## Appeal Decision

**Appeal Ref: APP/R5510/D/21/3280568**

**14 Nicholls Avenue, Uxbridge UB8 3JL**

- The appeal is made under section 78 of the Town and Country Planning Act 1990 against a refusal to grant planning permission.
  - The appeal is made by Mr Mohammed Haji against the decision of London Borough of Hillingdon.
  - The application Ref 788/APP/2021/1573, dated 20 April 2021, was refused by notice dated 15 June 2021.
  - The development proposed is a single rear/side extension and all associated works.
-

Revision	No.	Description	Date
----------	-----	-------------	------

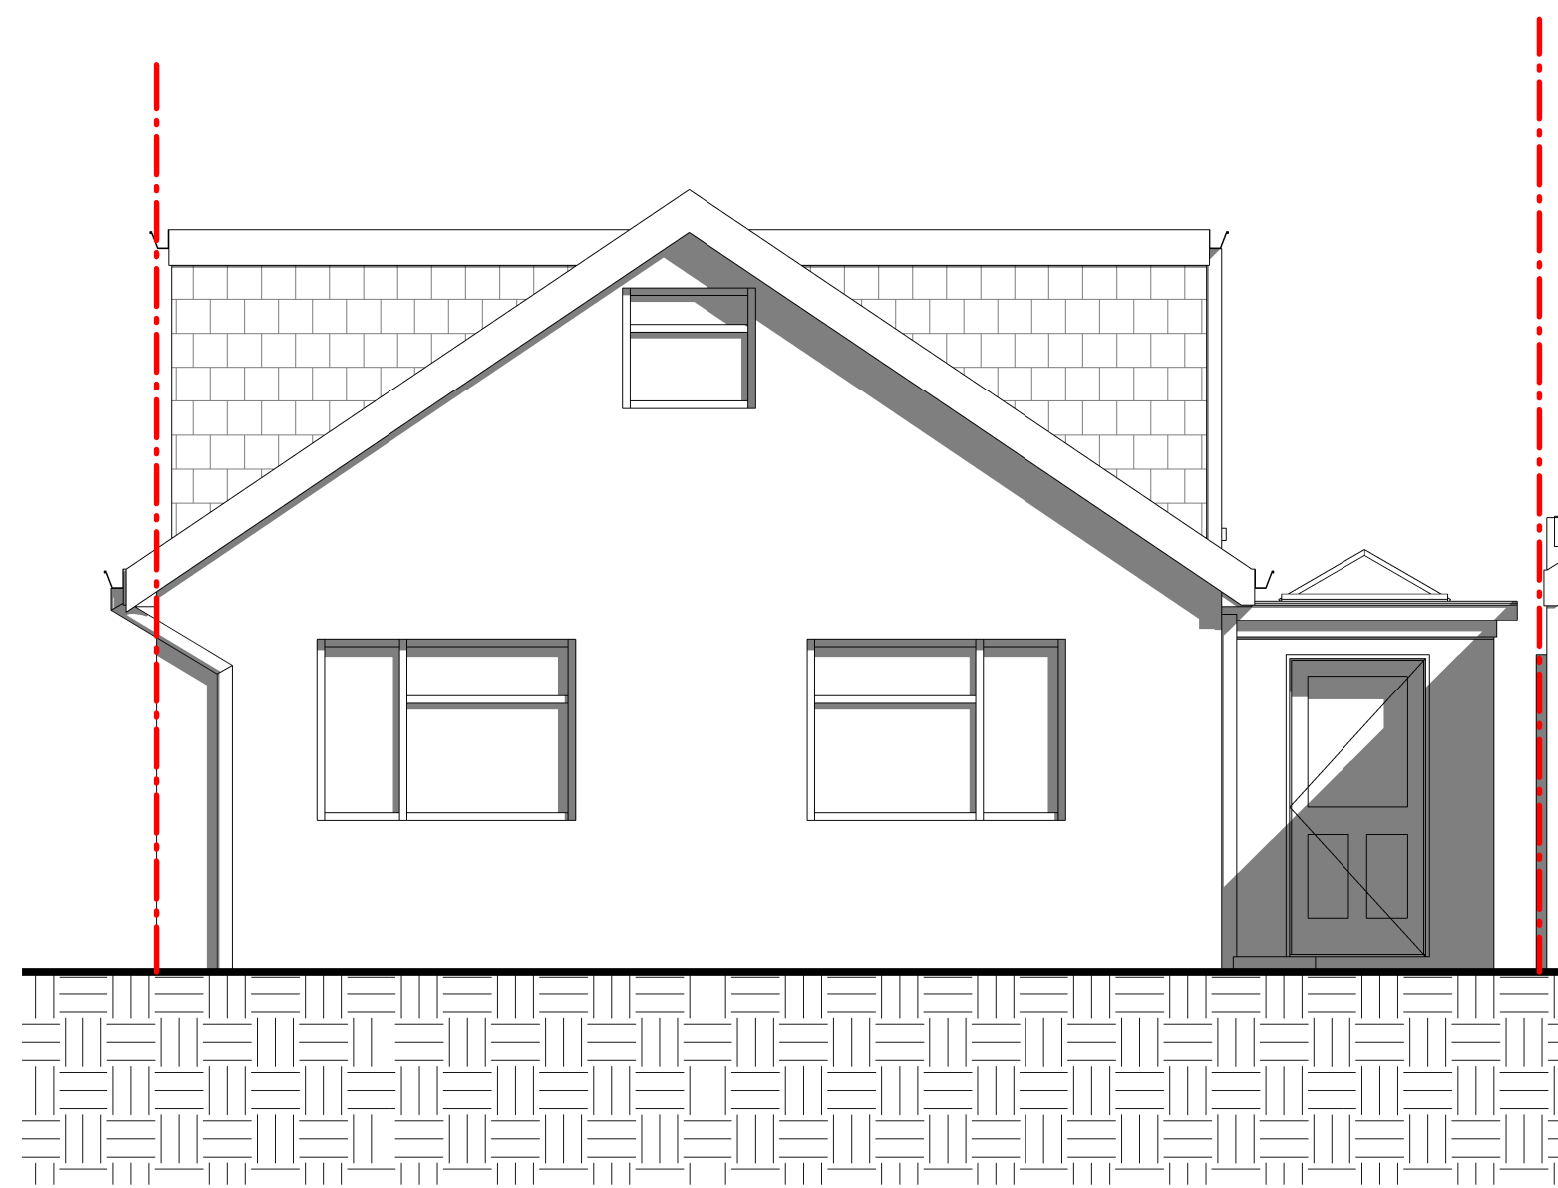
10. At the site visit I saw that many properties in the local area have been subject to various extensions but by no means all properties, the area and appeal property still retained the overall character of modest dwellings set within their own respective well-proportioned plots. The proposed development, as shown on the submitted plans would envelop the appeal property fundamentally changing the character and appearance of the property harming the character and appearance of the area.

12. Policy DMHD 1 of the DM requires that, amongst other matters, rear extensions to detached houses should not exceed 4 metres in depth.
13. The appeal scheme would project some 5 metres along the shared boundary with 16 Nicholas Avenue from the rear elevation of the appeal property that is situated approximately level with the rear elevation of the No.16.
14. In support of the appeal the appellant has detailed that the proposed extension would project 4m from the rear wall of No.16 and that "the 45-degree sightline is not infringed". While clearly stated, no substantive evidence has been provided to support this assertion and at the site visit I saw that there were windows in the rear elevation of No.16 adjacent to the boundary with the

appeal site. As such I am not satisfied that it has been demonstrated that the appeal scheme would not break the "45-degree line".

17. As a result of the significant projection of the proposed extension beyond the rear elevation of the appeal property and that of No.16, the appeal scheme would result in unacceptable harm to the living conditions of the occupiers of that property with particular regards to outlook and overshadowing.
